Project Name:	Clare Court, Barnham Road, Eastergate
Document Reference:	121.0008/HPSR/1
Document Name:	Highways Post Submission Response
Prepared By:	Caitlin Turley (April 2022)
Checked By:	Sam Coleman (April 2022)
Approved By:	Jessica Lloyd (April 2022)

- 1.1 In February 2022, a planning application (BN/16/22/PL) for four new residential units to the rear of Clare Court, 67 Barnham Lane in Eastergate was submitted to Arun District Council. As part of this application, a Transport Statement (prepared by Paul Basham Associates) was submitted to support the scheme. In March 2022, West Sussex County Council (WSSCC) highways provided comments on the planning application. This Highways Post Submission Response (HPSR) has been prepared by Paul Basham Associates on behalf of Batcheller Monkhouse to respond to these comments.
- 1.2 The site is located off Barnham Road in Eastergate, approximately 350m north-west of Barnham Railway Station and 1km south-east of Eastergate. The site location is shown below in **Figure 1**.

PROPOSED SITE PLAN . Scale 1:250 at A3

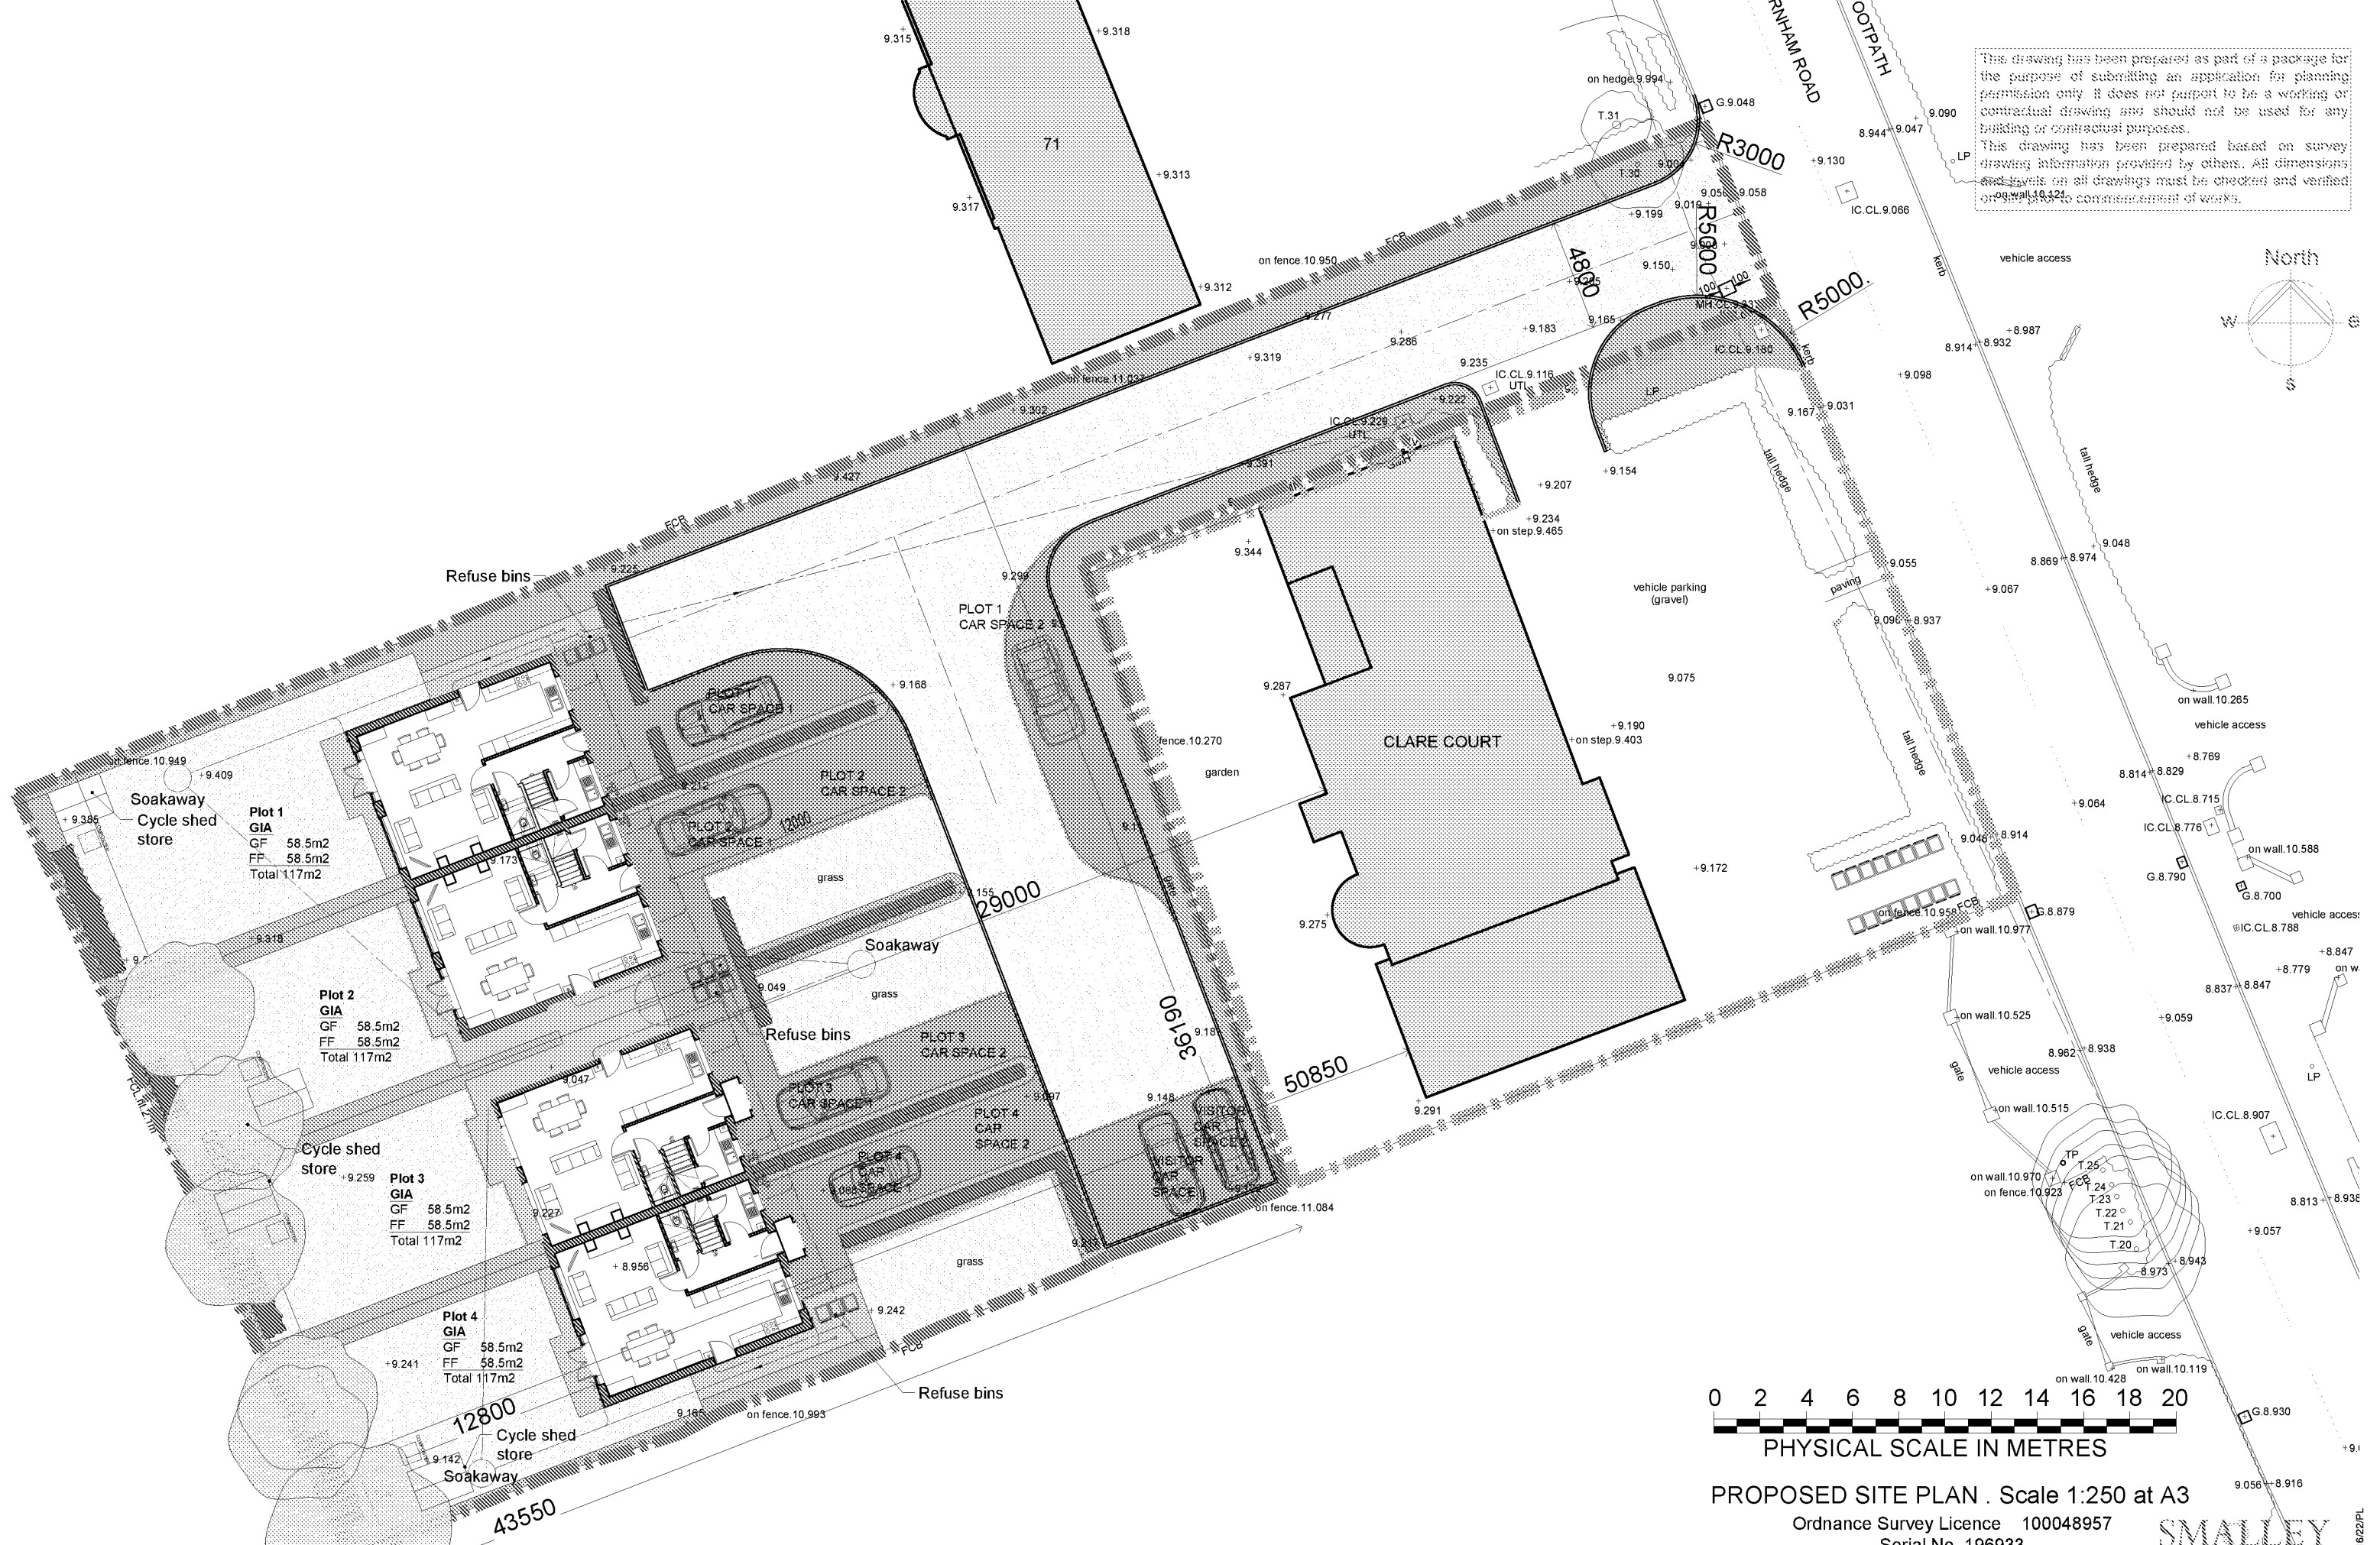
The existing access currently served Clare Court which consists of 8 flats. The TS details that the access point will be improved with a bell mouth style construction with a 5m kerb radii south of the access and 3m kerb radii north of the access. Vehicle tracking for a refuse vehicle demonstrates that this geometry would work.

For access points serving this number of dwellings it is typically more appropriate for the access to be a vehicle crossover style rather than a bell mouth set out with kerb radii.

The applicant may wish to consider this modification. Suitable tracking would be required to demonstrate the width of any proposed vehicle crossover would work. A vehicle crossover style access would be more in keeping with neighbouring access points.

Access within the site to the dwellings will be achieved via a 4.8m wide internal access driveway. This is wide enough to facilitate passing of two vehicles, and the passing of a vehicle sharing the space with pedestrians.

- 2.4 The suggestion of a vehicle cross over instead of a bellmouth is acknowledged and the development proposals have been updated to reflect this. Swept path analysis showing a refuse vehicle entering, turning around on side and exiting is included in **Appendix A** of this TN.
